DOC17/506187-01
SSD 7974

**SSD 7974 – SYDNEY UNIVERSITY HEALTH PRECINCT (STAGE 1) – ENVIRONMENTAL
IMPACT STATEMENT (EIS)**

SYDNEY UNIVERSITY HEALTH PRECINCT (STAGE 1)

Figure A1 Noise monitoring results for Location 6 (Hospital)

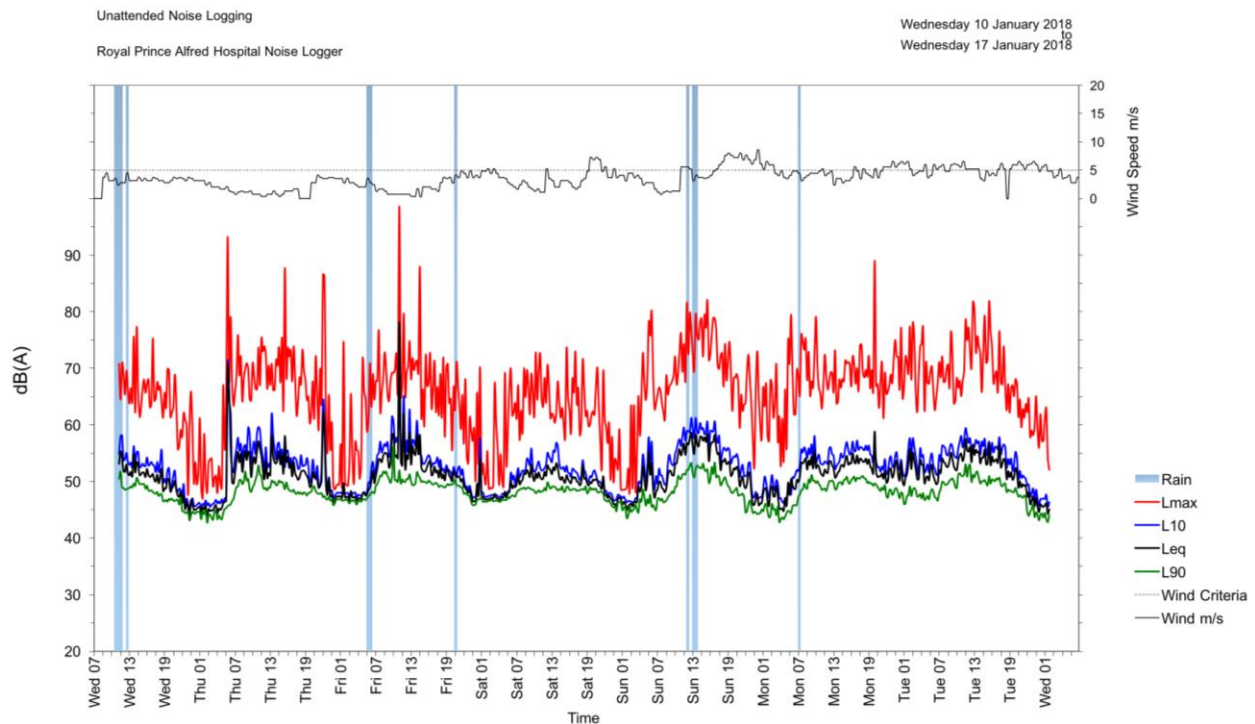
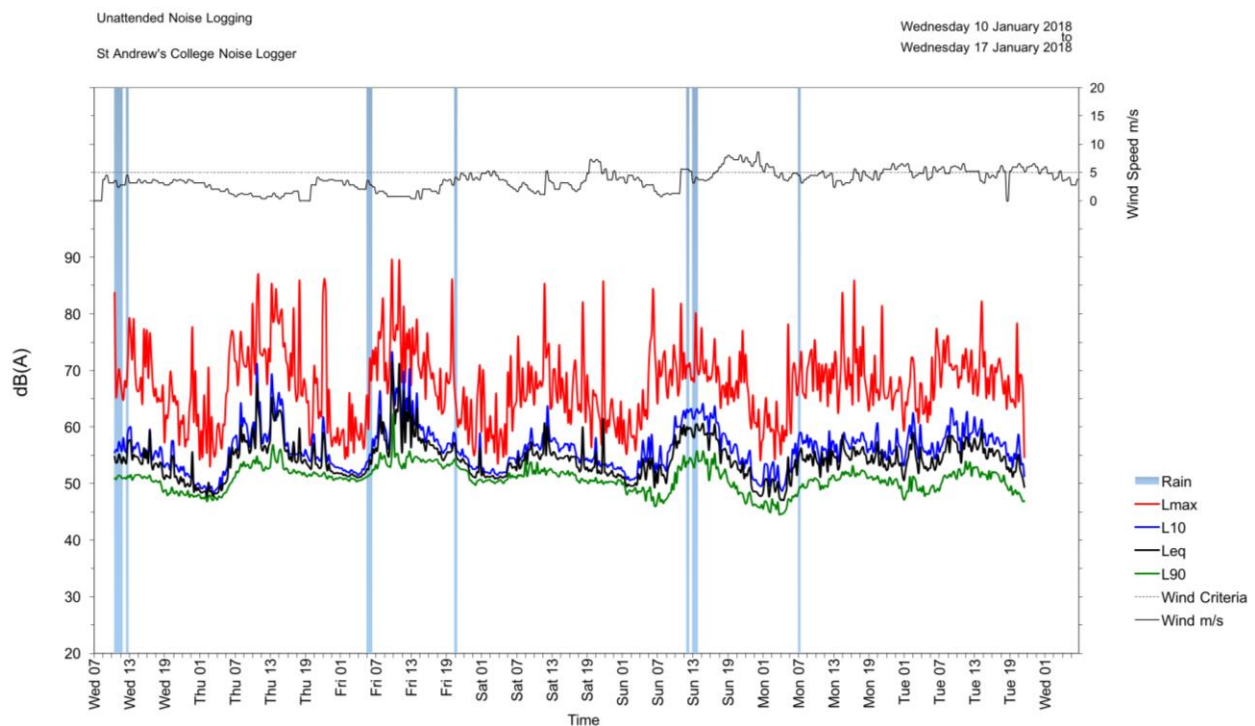
The EPA is concerned that monitoring to establish background noise levels was undertaken inconsistent with the guidance material provided in the INP. For instance, section 3.1 to EIS Appendix F '*SEARs Noise and Vibration Assessment*' indicates that unattended background noise monitoring was undertaken at Wesley residential college in 2012. However, the EPA understands that Wesley college is located within lot 1 in deposited plan 1171804 being part of the University campus.

The EPA is also concerned that EIS Appendix F only refers to the 2012 background noise measurements and does not provide any detail as to how those measurements were undertaken and whether not the equivalent of "... one week's worth of valid data ..." was obtained in a manner consistent with the guidance material provided in the INP.

The proponent be required to undertake background noise monitoring consistent with the guidance material provided in the New South Wales industrial Noise Policy.
